Memo To: Nell Donaldson  
Barbara Barhydt  
From: David Margolis-Pineo  
Re: 72 Bishop Street – AVESTA Housing (2015-060)

The Department of Public Services has the following preliminary comments on the above mentioned site plan.

**BOUNDARY & TOPOGRAPHIC SURVEY**  
 AT  
 72 BISHOP STREET, PORTLAND, MAINE  
 MADE FOR  
**AVESTA HOUSING**  
 307 CUMBERLAND AVENUE, PORTLAND, MAINE

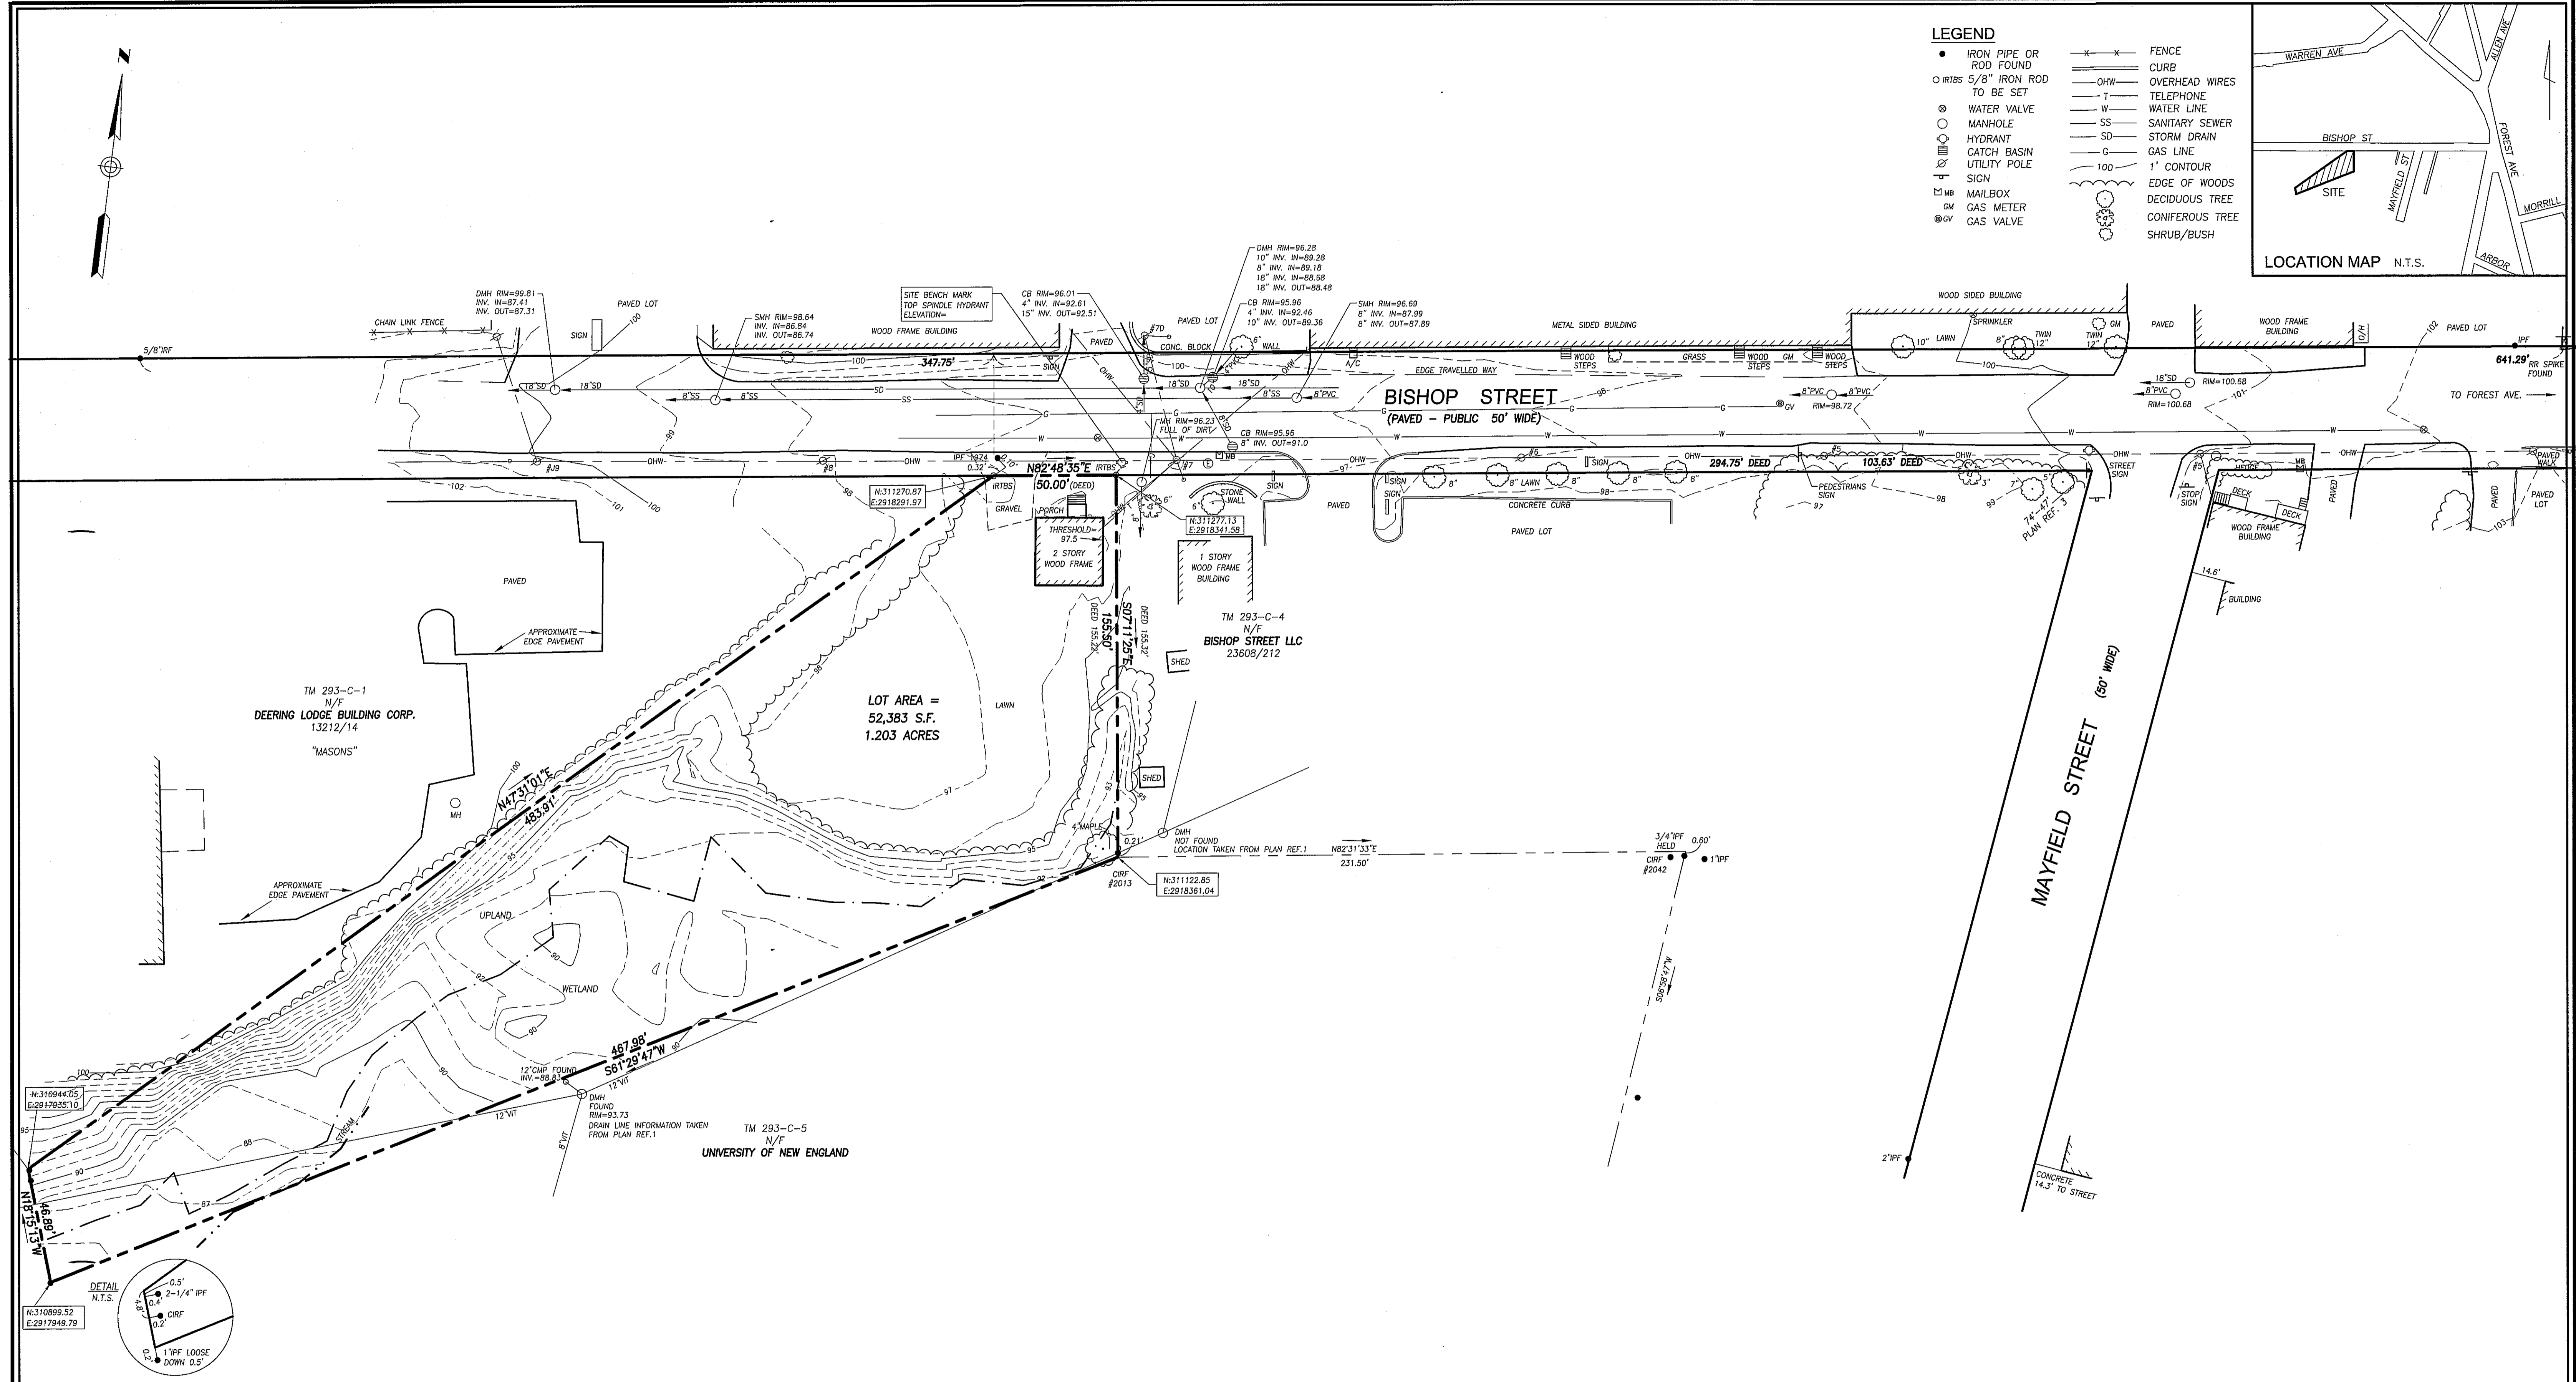
1. Surveying comments will be forwarded by William Clark of this office under a separate cover. Survey plan will require a Professional Surveyor stamp.

- Plan now stamped.
2. The applicant has agreed to extend a sidewalk to Forest Avenue. The plans show the sidewalk terminating at the parking lot prior to Forest Ave. It is desirable to have the sidewalk continued through this parking area to Forest Ave. Drive cut location(s) will need to determine with the parking lot owner.

BISHOP STREET
(PAVED - PUBLIC 50' WIDE)

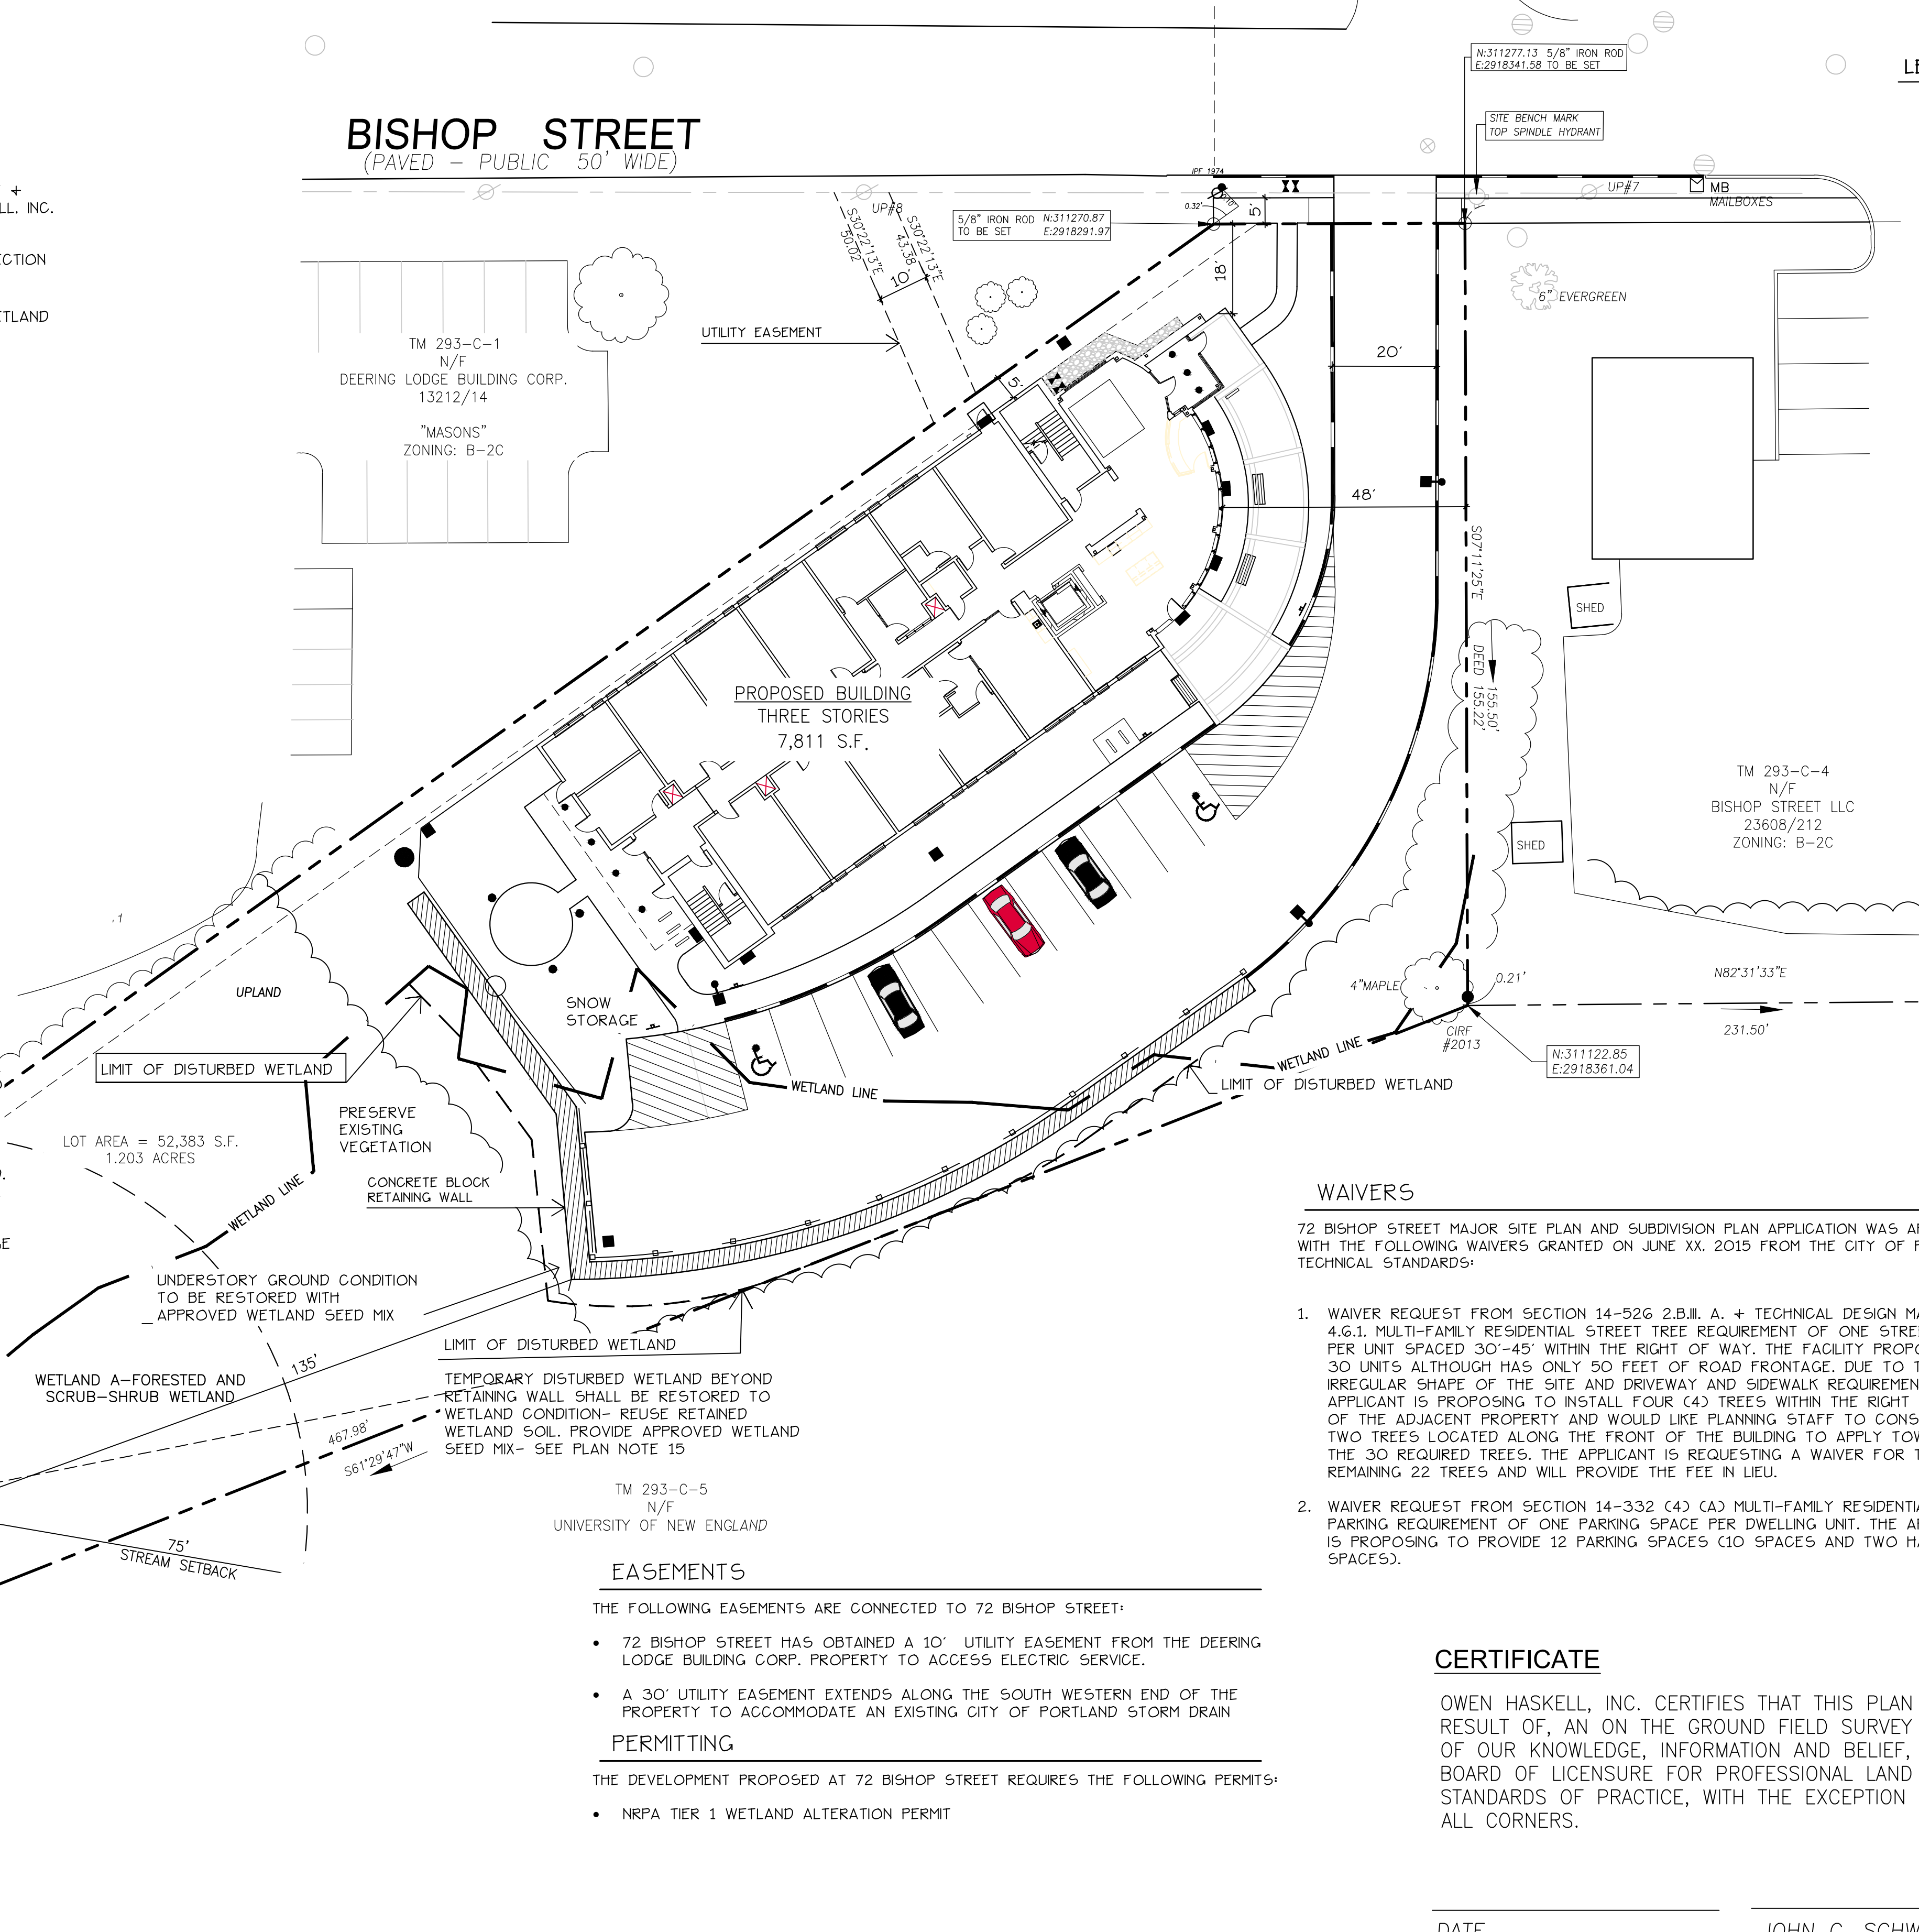
4. An existing stormwater drain is shown crossing the applicant's property. An easement will need to be shown on the survey plan for this utility. For an accurate easement, the cross-country drain manholes will need to be located. If necessary, the City can assist with locating.

- Easement has not been shown on the applicant's Subdivision Plat. It is recommended that as a condition of approval the applicant be required to add the drainage easement to the Plat.
